From: Amanda Scholes on behalf of Planning.Responses
Sent: 01 December 2021 09:57
To: Planning Scanning
Subject: FW: Planning Consultation on: P/153/21/RES

From: Laura Gibbons [REDACTED]
Sent: 30 November 2021 15:07
To: Planning.Responses [REDACTED]
Cc: David Easton [REDACTED]
Subject: RE: Planning Consultation on: P/153/21/RES

Engineers Comments Regarding Surface Water Drainage

Application No: P/153/21/RES
Registered: 8th November 2021
Site Address: Land South of Summer Lane and West of Pagham Road Pagham
Grid Reference: 488747 98017
Description of Works: Approval of reserved matters (appearance, layout, landscaping and scale) following outline planning Permission P/140/16/OUT for the erection of 375 No dwellings, together with public open space, play space, drainage, parking and associated infrastructure, landscape, ancillary and site preparation works, with access off Pagham Road. This site may affect a Public Right of Way.

Drawing No. **D1915-300** Rev. **L**

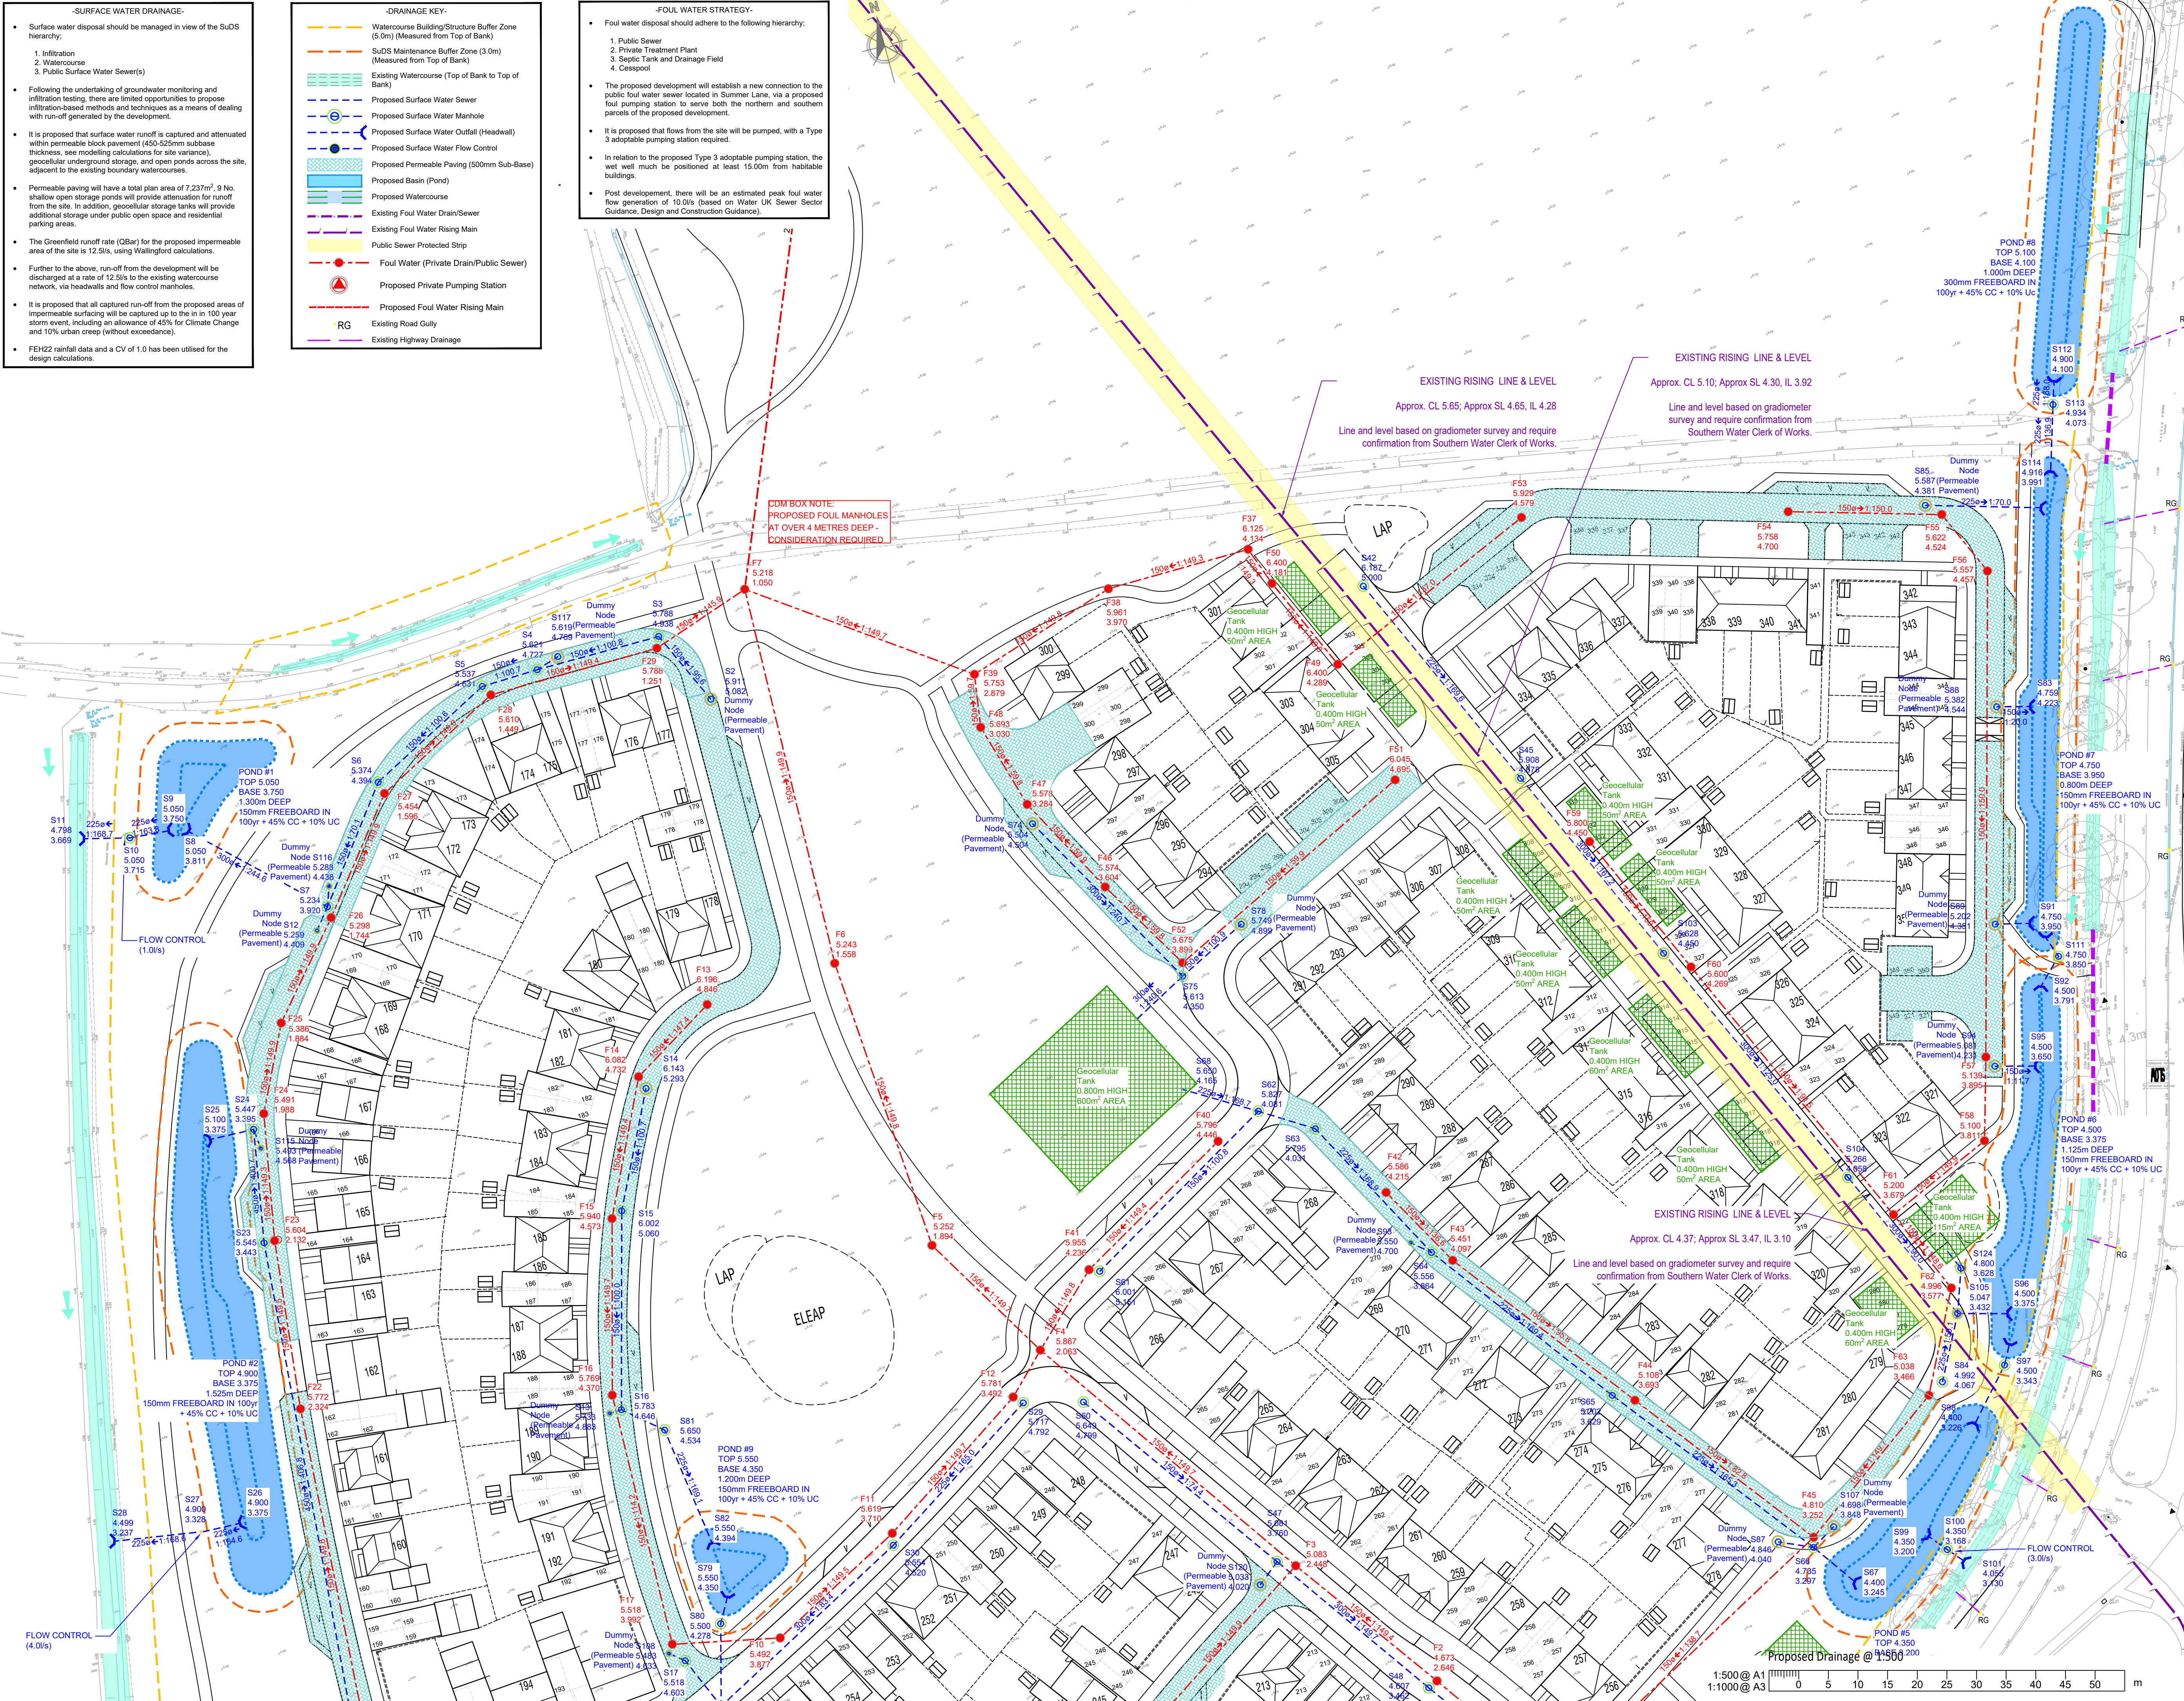
4. We query the flow directions of ordinary watercourses stated on plans.
 - a. The watercourse to the south of the site, shown on SW Drainage Strategy (Southern) Sheet 2 of 2, is shown to flow east to west on the applicants proposals. Our records and levels appear to show this flowing west to east.

- b. The watercourse to the north east of Pond #1, shown on SW Drainage Strategy (Southern) Sheet 1 of 2, is shown to flow west to the east on the applicants proposals. We believe this flows east to west, and this is supported by topographic levels.

- c. The watercourse which forms a T shape immediately to the west of the proposed access route, shown on SW Drainage Strategy (Northern) Sheet 2 of 2, is shown to flow north and then west. We believe this flows south. We also note that the surface water drainage layout indicates that no culvert has been found at this farm crossing. Our records indicate that a culvert is present. The vegetation and silt needs to be cleared to investigate the presence of this culvert.

8. We note that it is proposed to take a new long culvert along this watercourse to the east of Horns Lane, connecting to the western watercourse a considerable distance downstream. We do not support this proposal. The existing watercourse needs to be thoroughly investigated and the culverted length should be minimised, it may be that the watercourse already connects immediately to the west. We also cannot support proposals for what we believe are parking spaces, in this corner until the presence of existing culverts has been established.

9. It is not clear what the thick hatched line to the west of Horns Lane at its northern extent dictates. Please confirm.
10. Some of the proposed basins appear to be within the watercourse buffer extents.

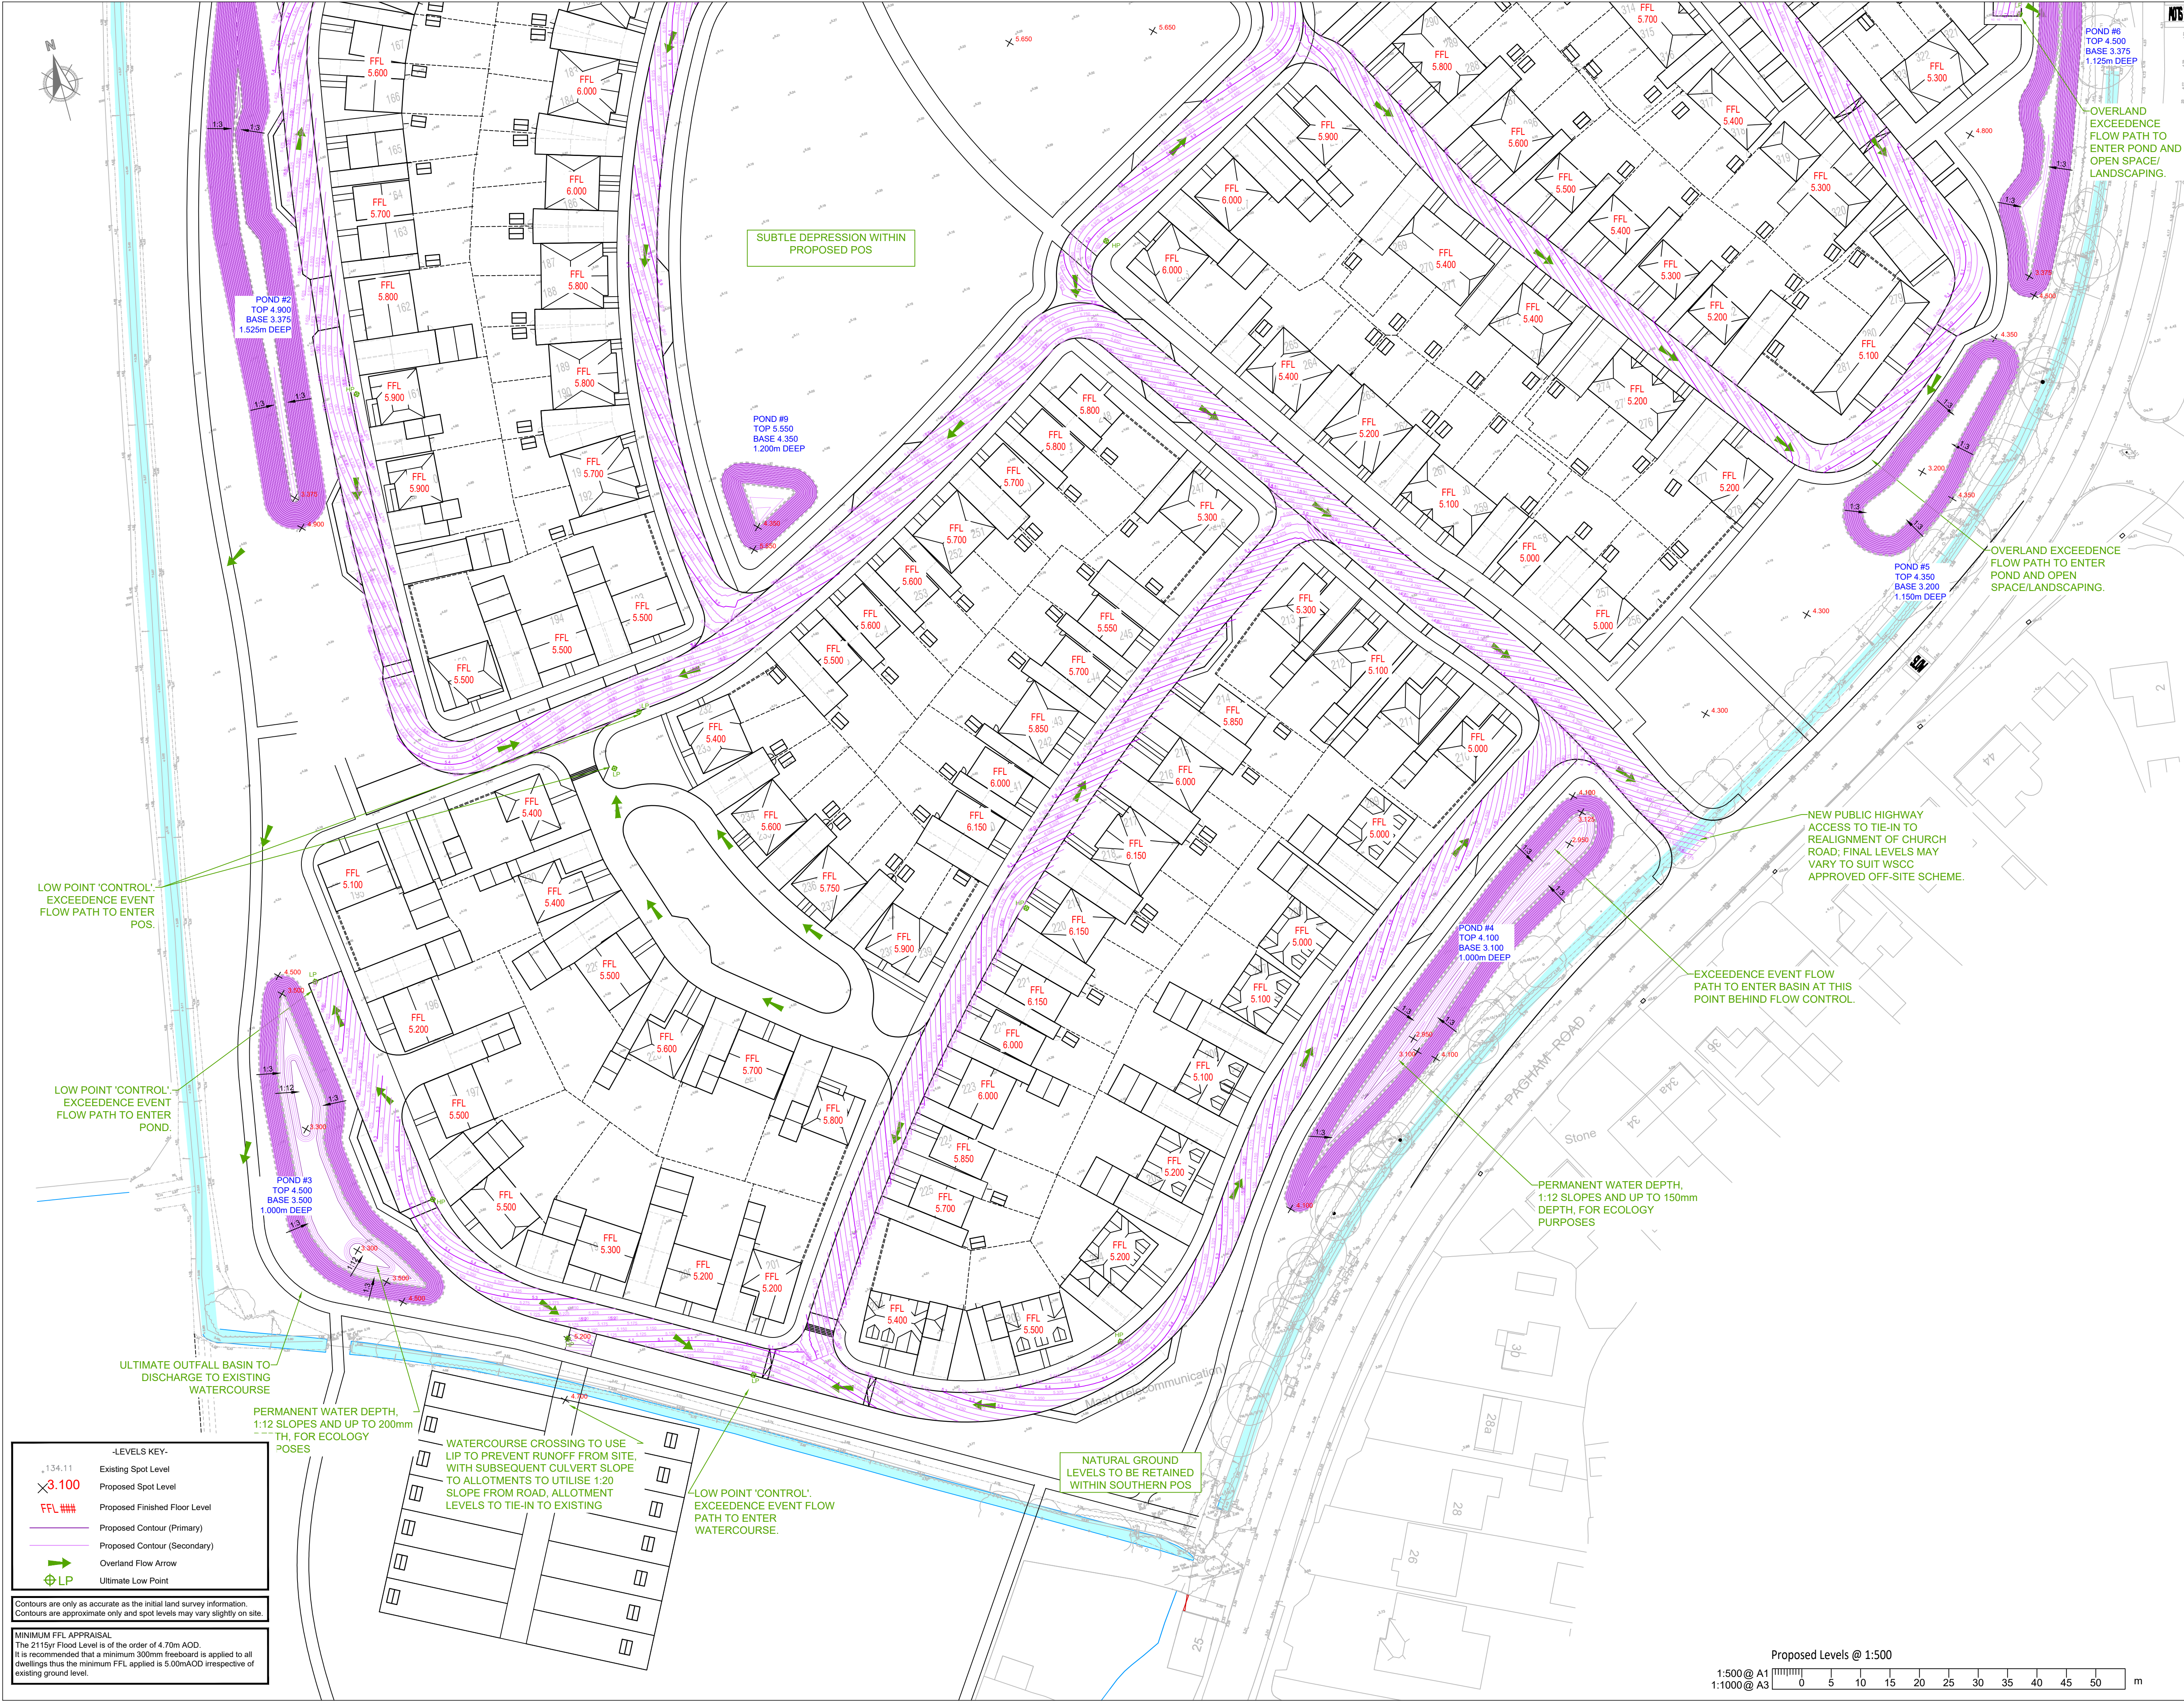
2. Significant ground raising is proposed as part of the development, with some areas proposed to be raised by over 1.5m. We would strongly recommend that the planning officer reviews proposed levels.
